Response to Planning Application

From: Arun District Council Greenspace

Application ref: CM/48/21/RES

Location: Land to the West of Church Lane South of Horsemere Green Lane Climping

Public Open Space Key Diagram

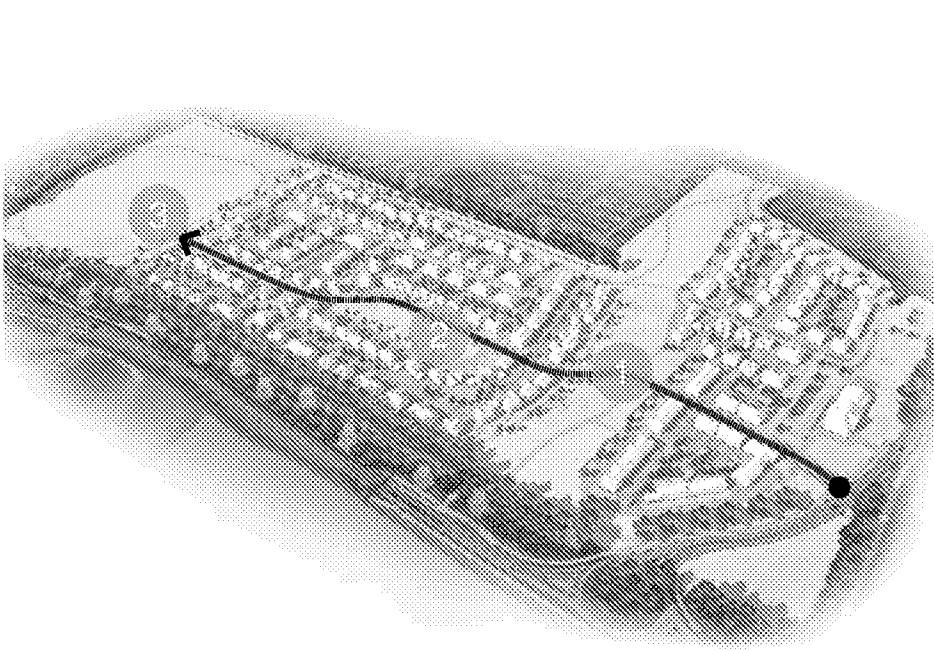
The LAPs need to provide for younger children with natural elements incorporated such as mounding, boulders, logs, planting seat and bin. The LAP shown within the Central Green POS area adjacent to the SuDS area and viewing platform needs to be relocated away from any SuDS feature. ROSPA would recommend a 30m buffer between play and SuDS.

Pathways appear to be mown grass which are not all year round accessible or DDA compliant, recommend pathways in high trafficked, primary routes and to destinations such as play area are Tarmac in finish.

Public Open Space Key Diagram

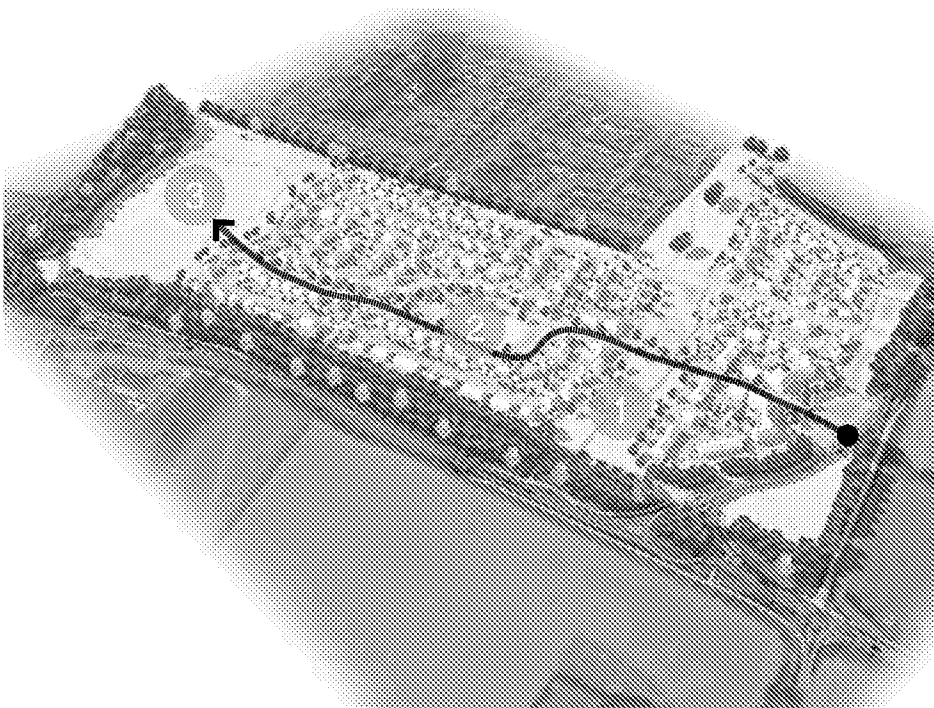
Trees where shown located on made-up ground (mounds) are not considered to be conducive to establishment, these trees should be re-positioned locally to ensure they will thrive and are achievable of long term retention.
